PLANNING CONSULTATION RESPONSE

Application No	2024/0993
Proposal	Erection of access gate and resurfacing of service road.
Address	Land off Wood Street, Wombwell, Barnsley, S73 0LH.
Date of Consultation Reply	12/03/2026
Consultee	Edward Jowett (Tree Officer)

Appendix 4:
 Tree Works Plan
 View 1
 Land at Wood Street, Wombwell, Barnsley
 Ref: AWA7164
 BRITISH STANDARD 5837:2012
 SCALE: 1:500 PAPER: A2

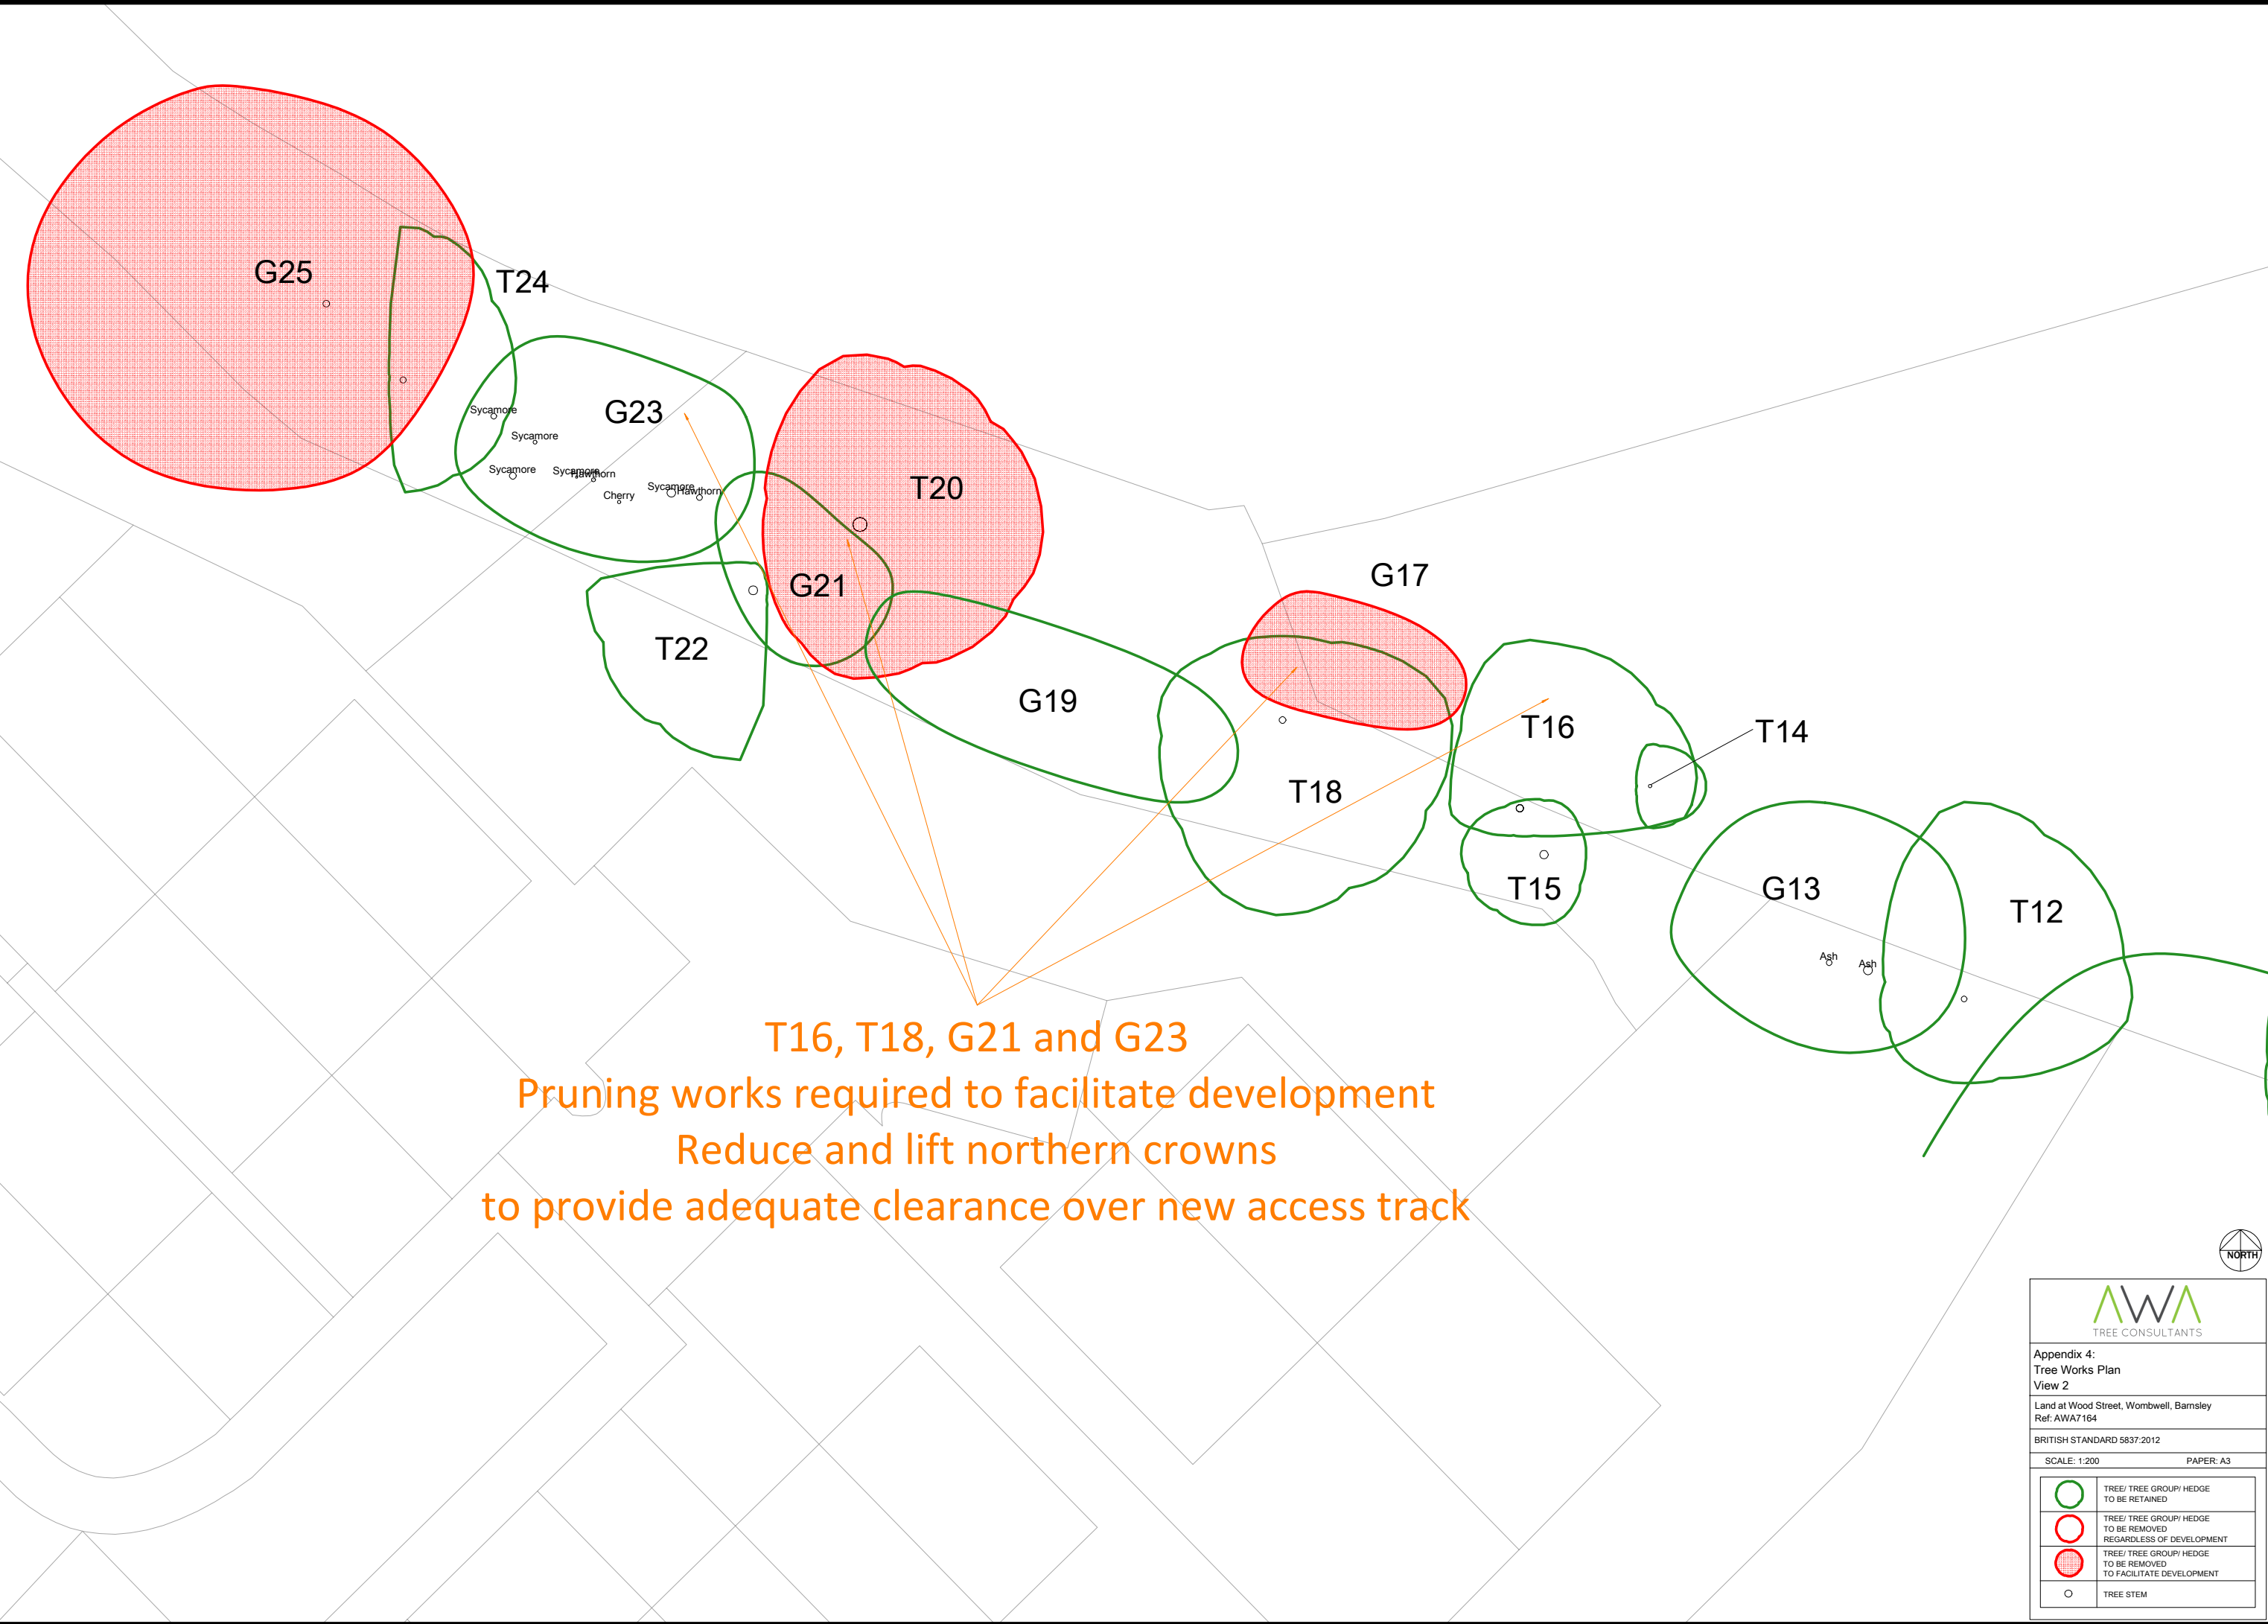
An arboricultural method statement has now been submitted for this application which shows the tree removals required to facilitate the works along with a plan detailing the construction of the track using minimum dig construction methods and as such these documents will need to be noted as approved documents to be complied with.
